Trinity Grammar School (Summer Hill Campus) - The Renewal Project

RESPONSE TO SUBMISSIONS

06 NOVEMBER 2020

In June 2020, the School received a letter from the Department of Planning, Industry and Environment seeking response to submissions on a number of items. This document has been prepared in response to the following matters:

01 ELEVATION
DA200 Street Elevation 01
Scale 1:500

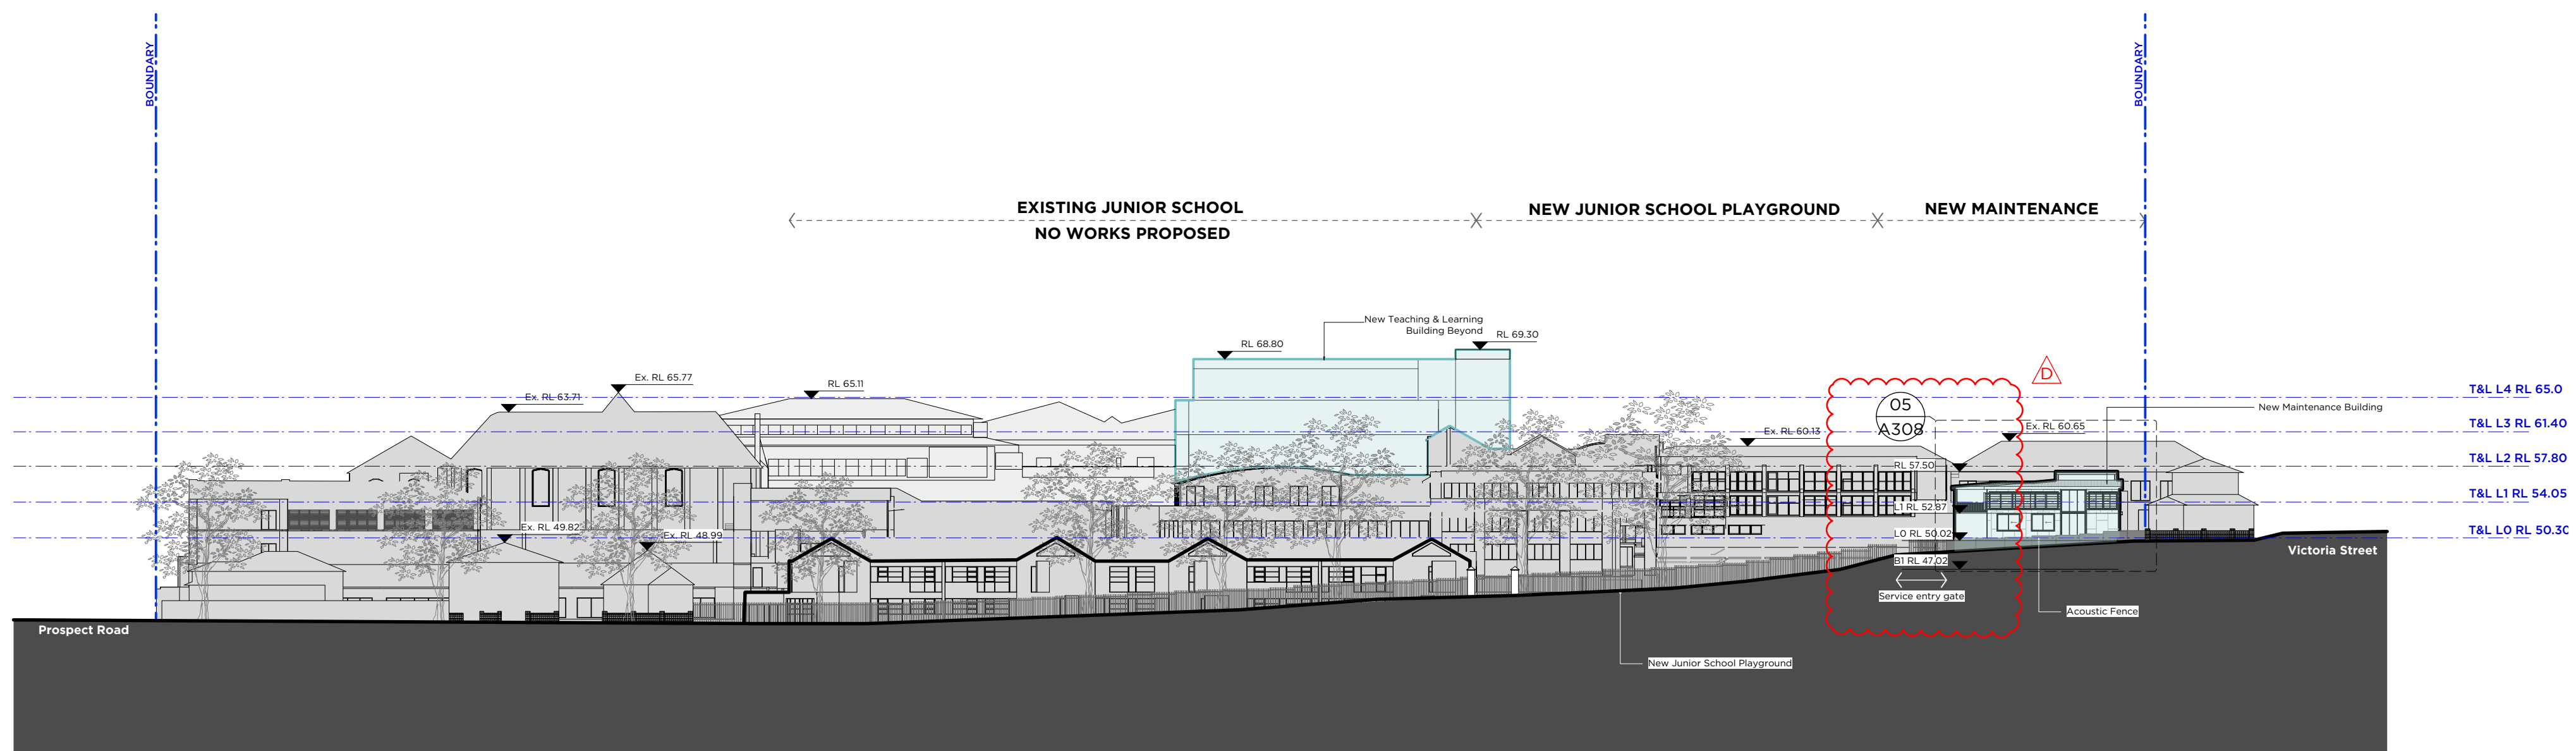
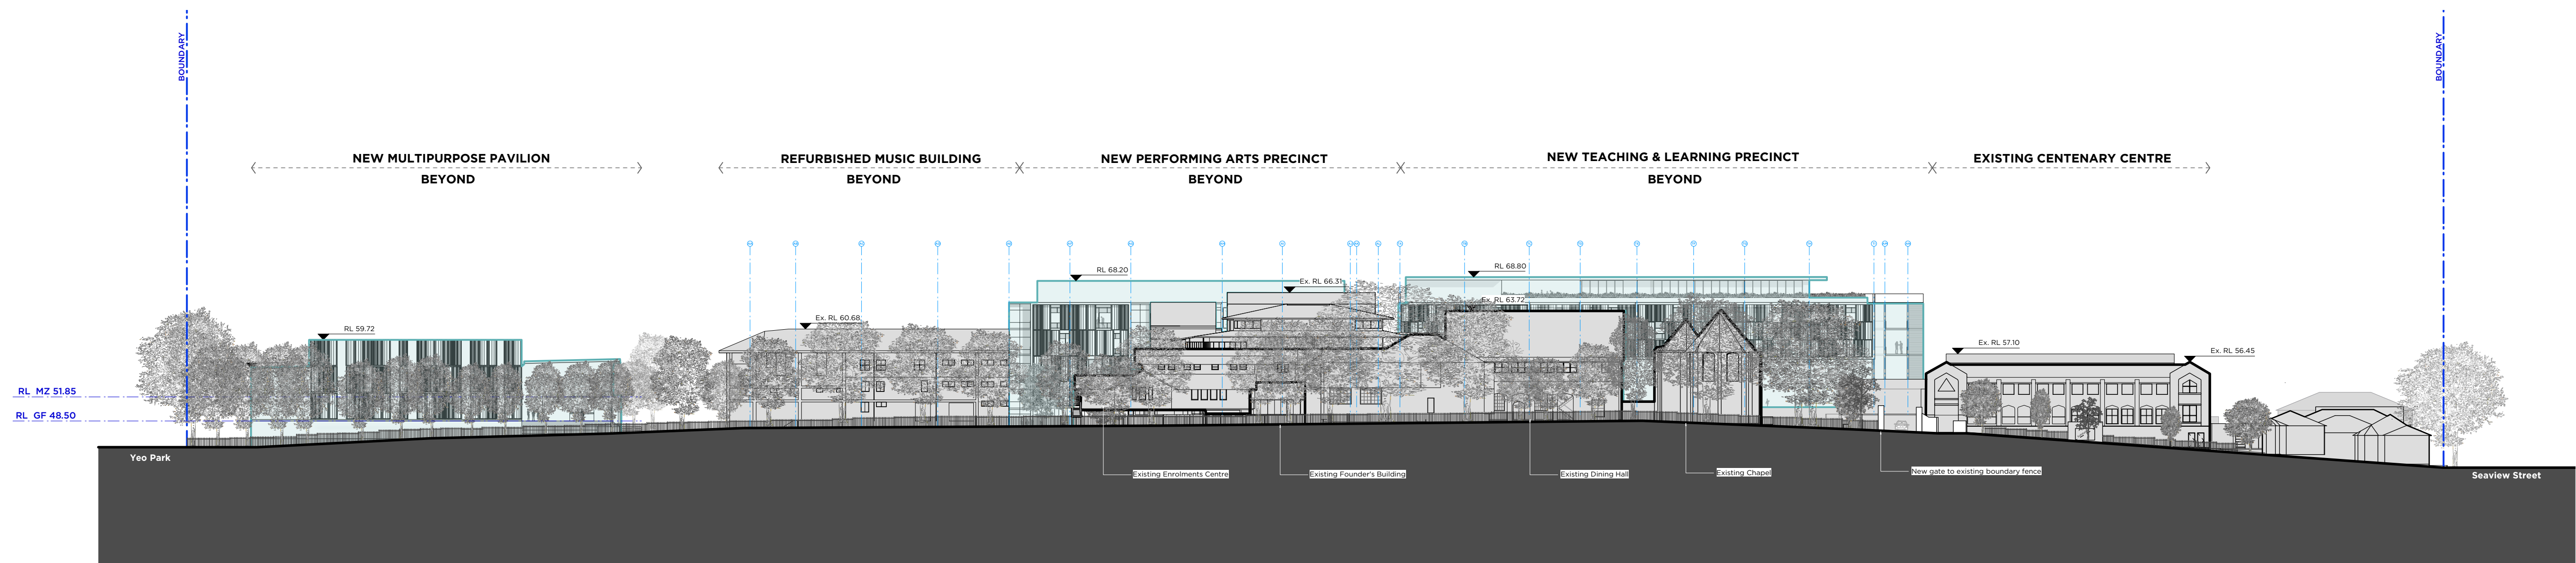
- The majority of the new buildings are located within the SP2 under the Ashfield Local Environmental Plan 2013. While there is no stipulated height limit within the SP2 zone, the five-storey built form at the centre of the site appears to be bulky and would adversely impact on existing views currently enjoyed by the neighbours.*

- While the impacts of the development on the views enjoyed by the neighbours is assessed as low to moderate, the Department considers that design options should be explored to reduce the overall the height and bulk of the five-storey built form. This may involve reducing or relocating the extent of program accommodated by the new teaching and learning and performing arts buildings and/or further articulation of envelopes and facades.*

Reduce height of Level 5 Roof by 500mm on T&L block and Mechanical enclosure by 400mm

The original proposed roof RL to top of Teaching & Learning block was RL69.30. The new updated design drops the level to RL68.80.

The original proposed mechanical plant enclosure was RL68.60. It is now proposed at RL68.20.

Updated elevations are submitted as part of the RtS and new photomontages with supporting visual impact assessment commentary by RLA in reference to the amendment.
